Addendum No. 1

RE: Contract ID: C202480

Bertie County (R-5195)

US-13/17 From SR-1102 To SR-1106

STATE	STATE PROJECT REFERENCE NO.	SHEET NO.	TOTAL SHEETS
N.C.	R-5195	1	
STATE PROJ. NO.	P.A. PROJ. NO.	DESCRIPTION	
45289.3.ST1	STM-0013(32)	CONST.

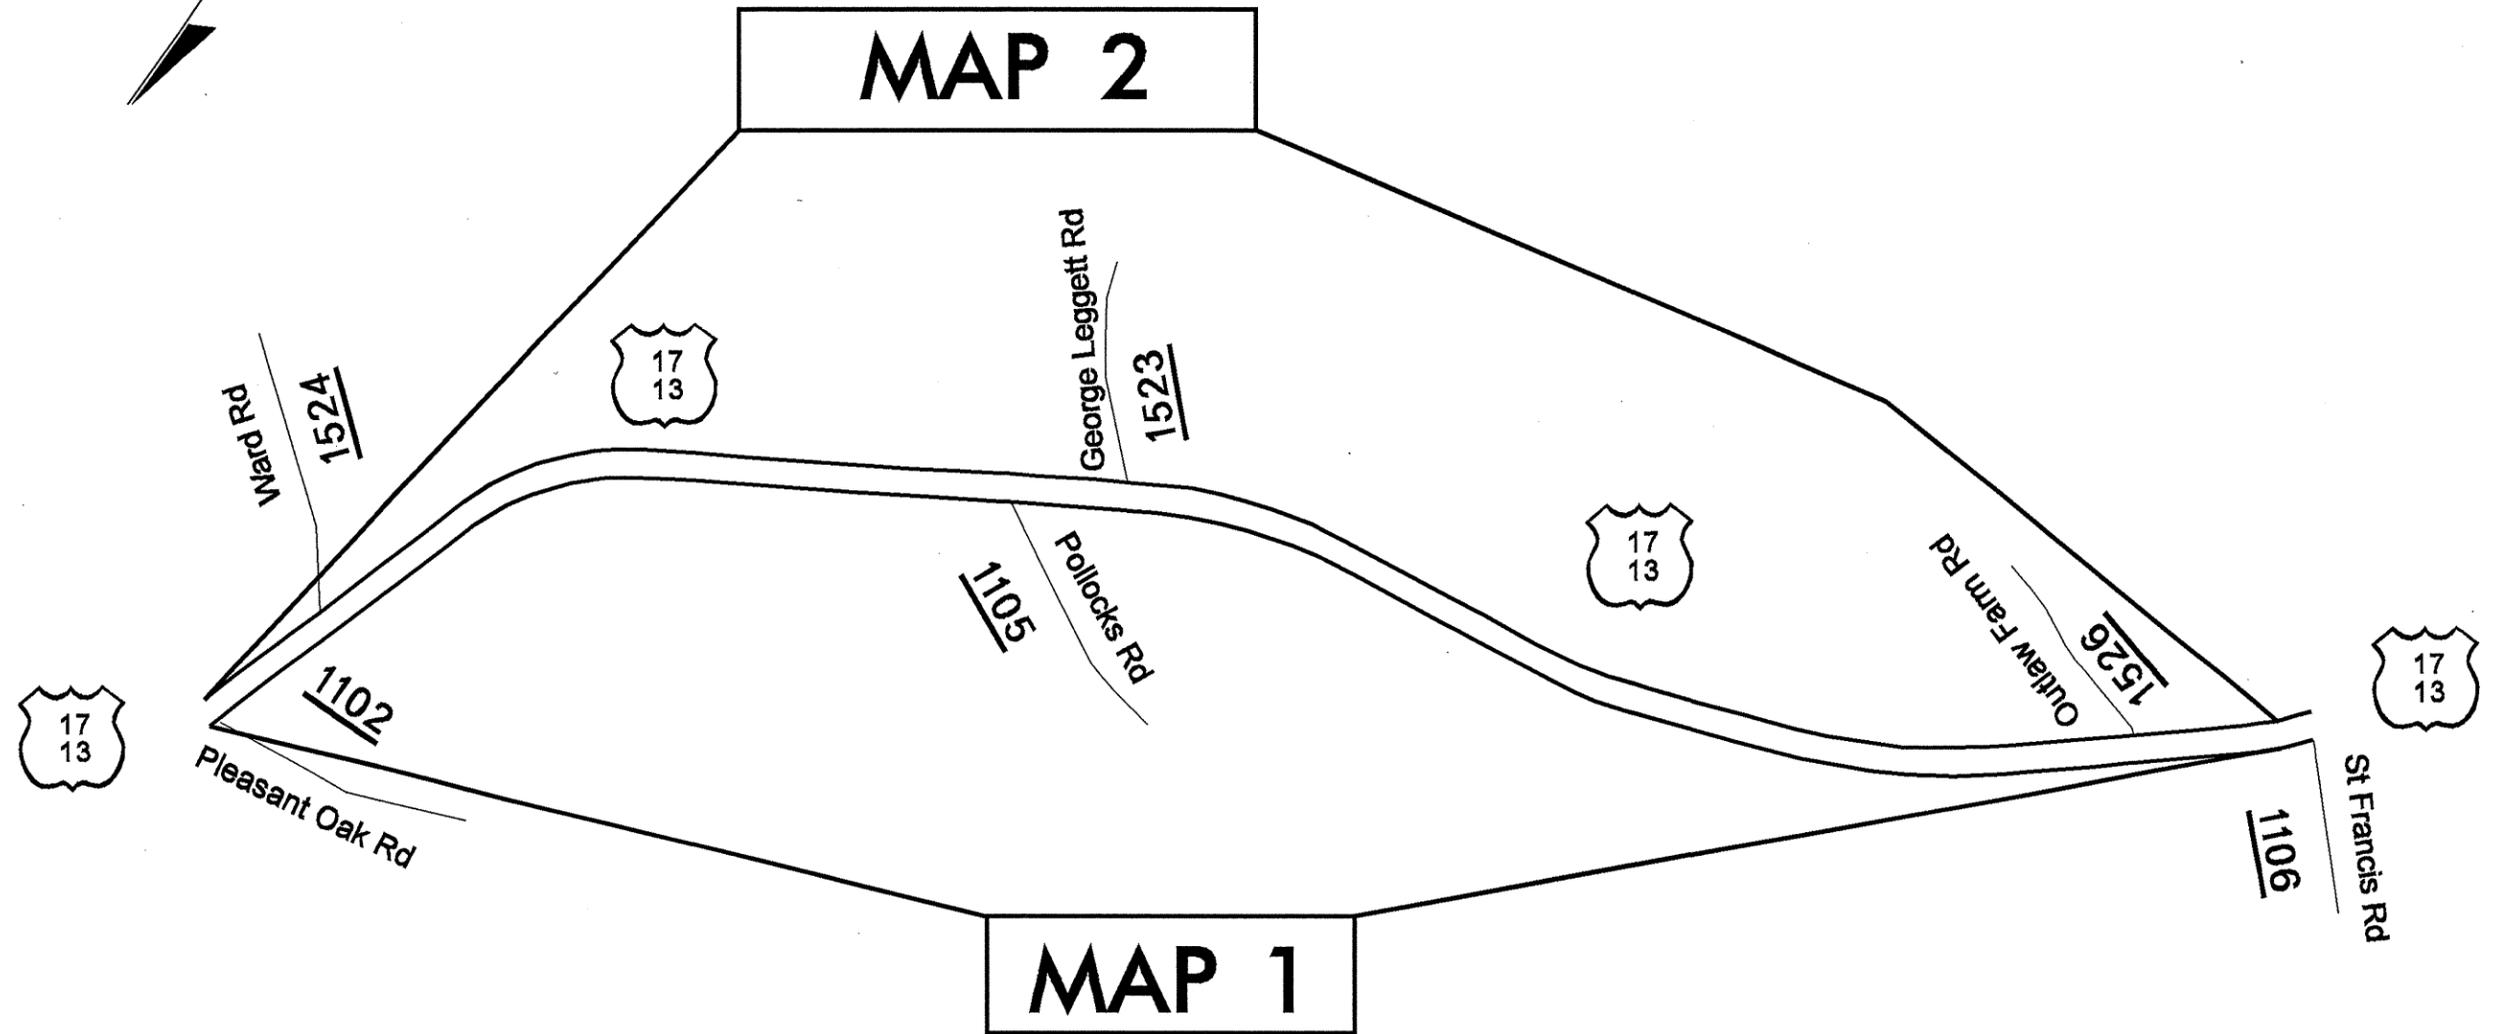
On Sheet No. 1 the label for "Map 1" and "Map 2" were reversed. Please void Sheet No. 1 in your plans and staple the revised Sheet No. 1 thereto.
